INFRASTRUCTURE PLANNING
THE INFRASTRUCTURE PLANNING (EXAMINATIONS PROCEDURE) RULES 2010
THE THANET EXTENSION OFFSHORE WIND FARM ORDER

**Comments on the Applicant's responses to action points arising from ISH8 submitted on behalf of the Port of London Authority and
Estuary Services Limited**

| Document Ref. | PLA 25 / ESL 25 |
| Date | 28 May 2019 |

Vessel Traffic Survey - Recreational Tracks.

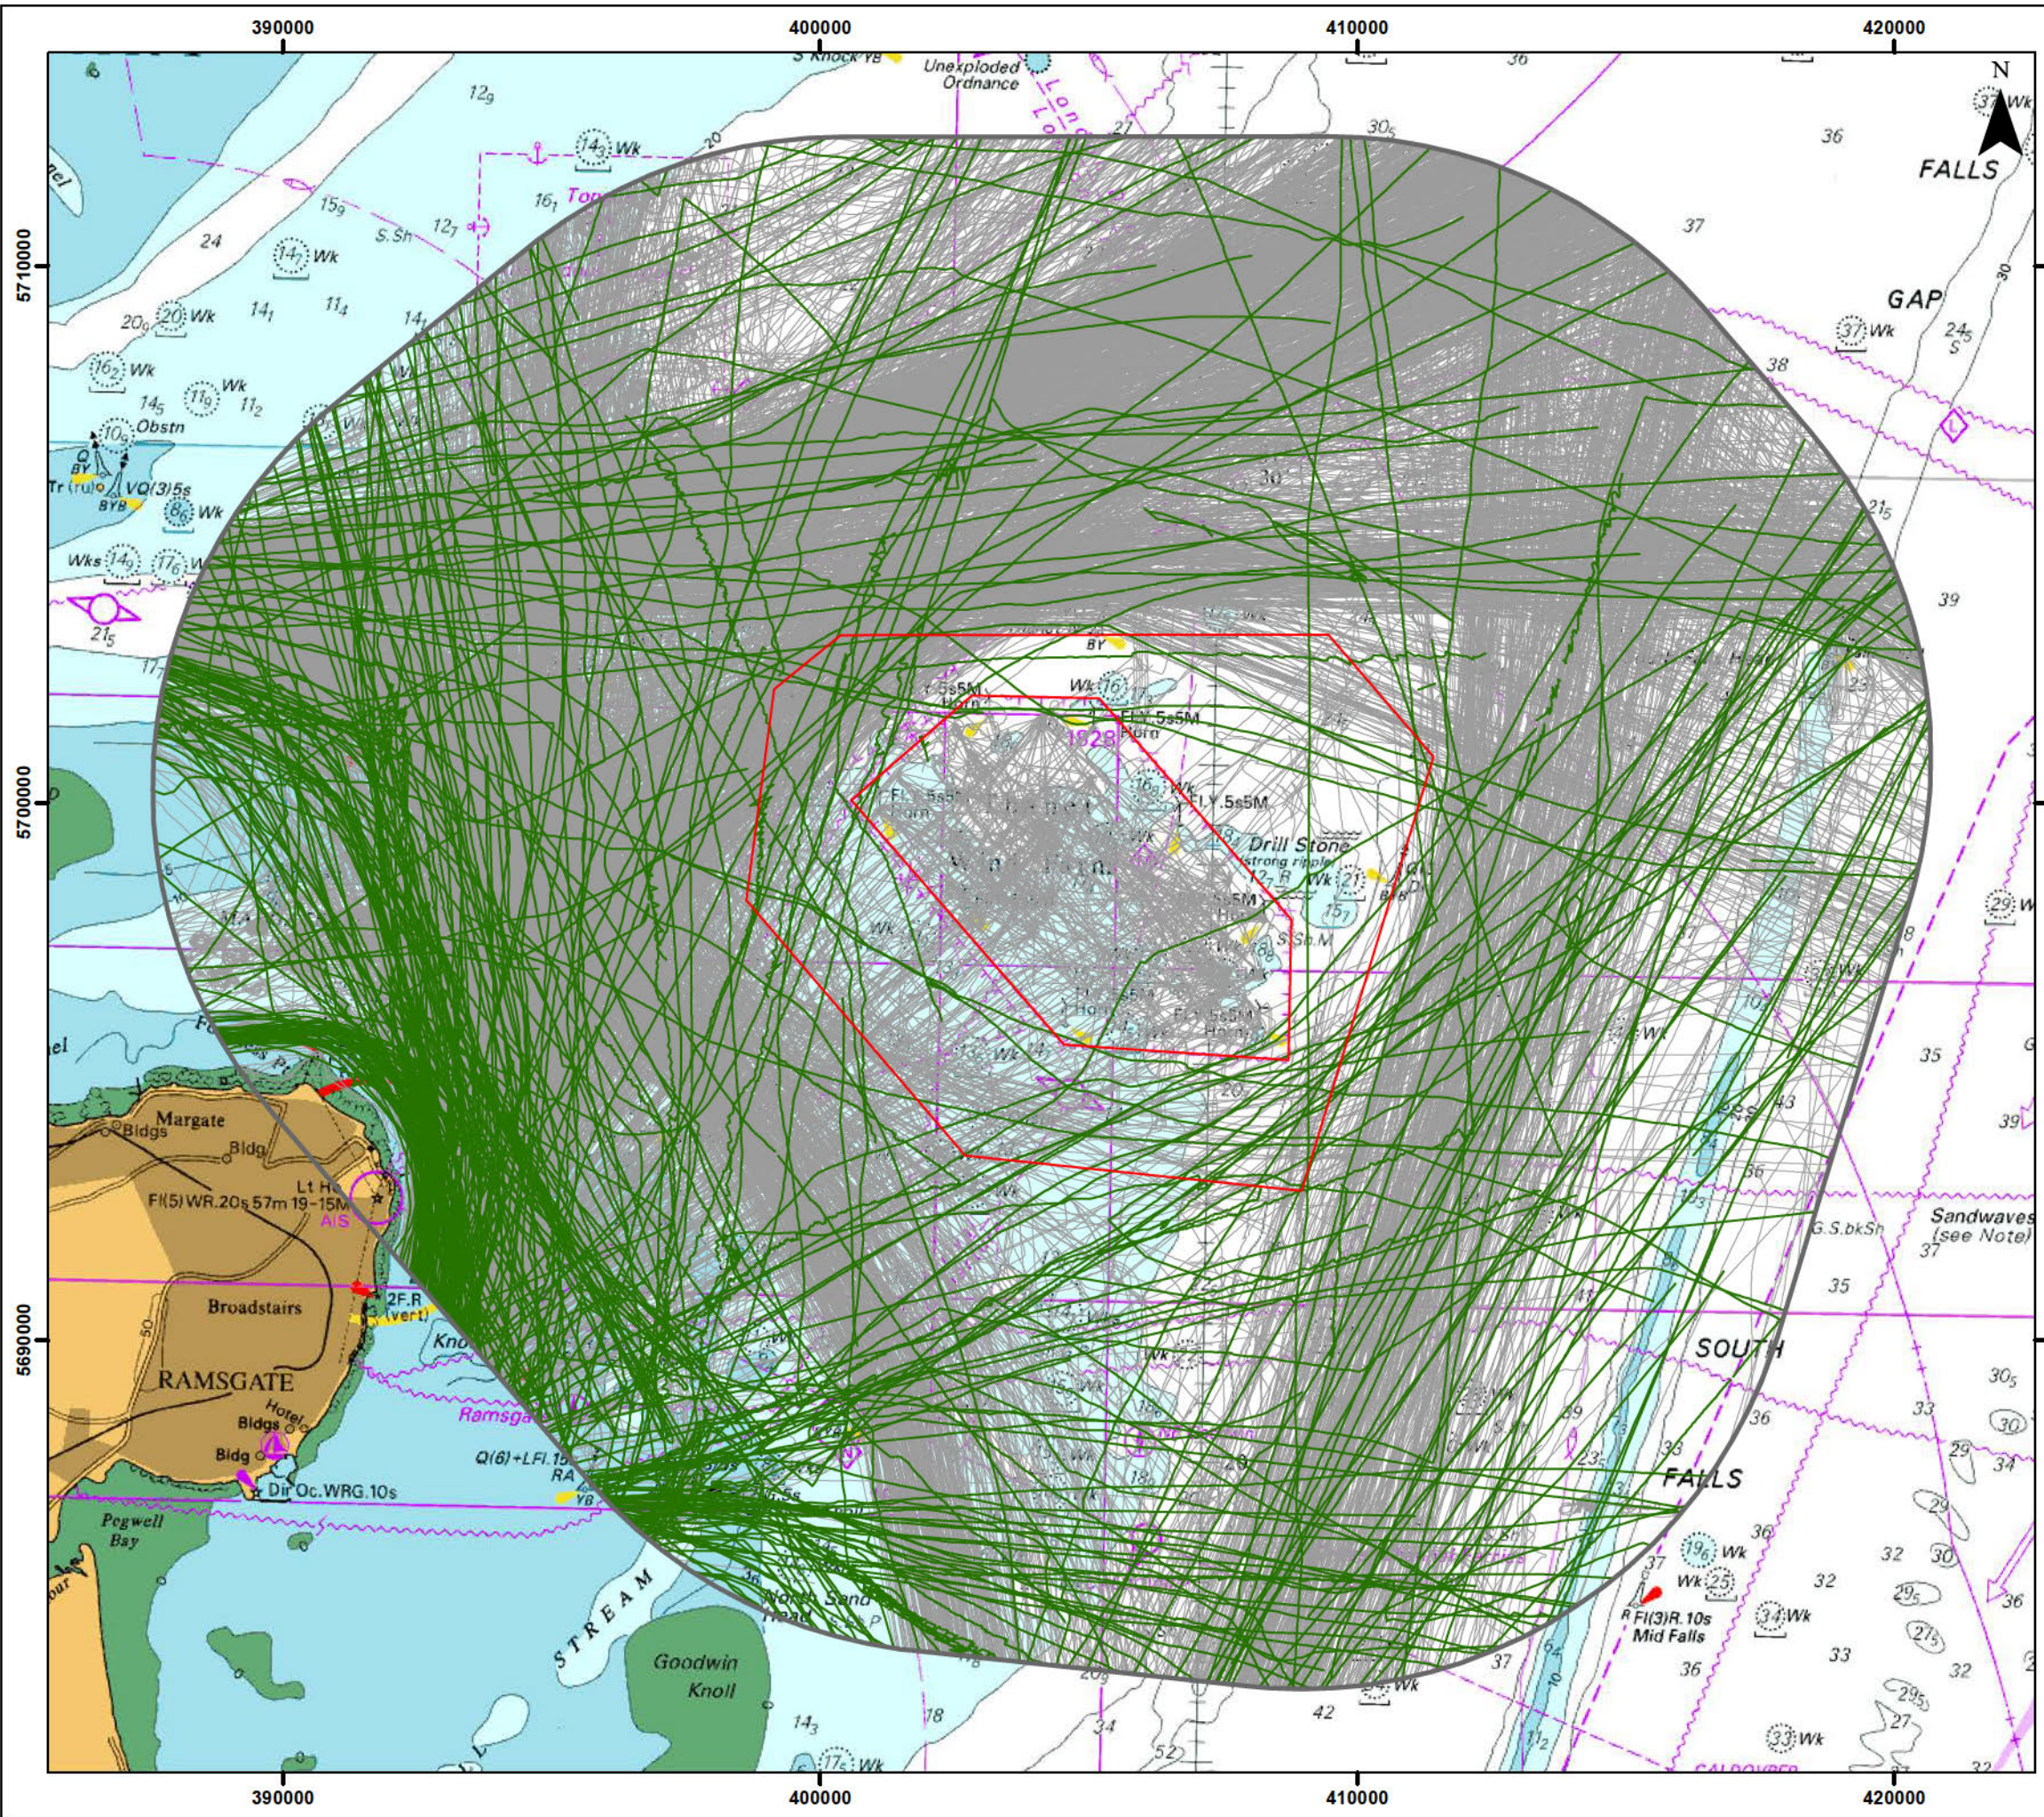
| Action Point | Response summary/extract | PLA/ESL comments |
|--------------|---|---|
| 5 | Para 52 – consideration of recreational craft | The Applicant's recreational craft assessment is still reliant upon AIS data which does not cover all recreational craft (Appendix 27 to Deadline 4: Data Analysis and Validation). Whilst the PLA and ESL agree that the RYA heat map can |

| Action Point | Response summary/extract | PLA/ESL comments |
|--------------|--|---|
| | | indicate route use for its members, they would still suggest the high volume of visiting recreational craft from Europe, in particular Holland and Belgium, is not recognised. This traffic is significant because of the approach it takes from the North of the windfarm through the inshore route, in ESL's experience more frequently through July and August. |
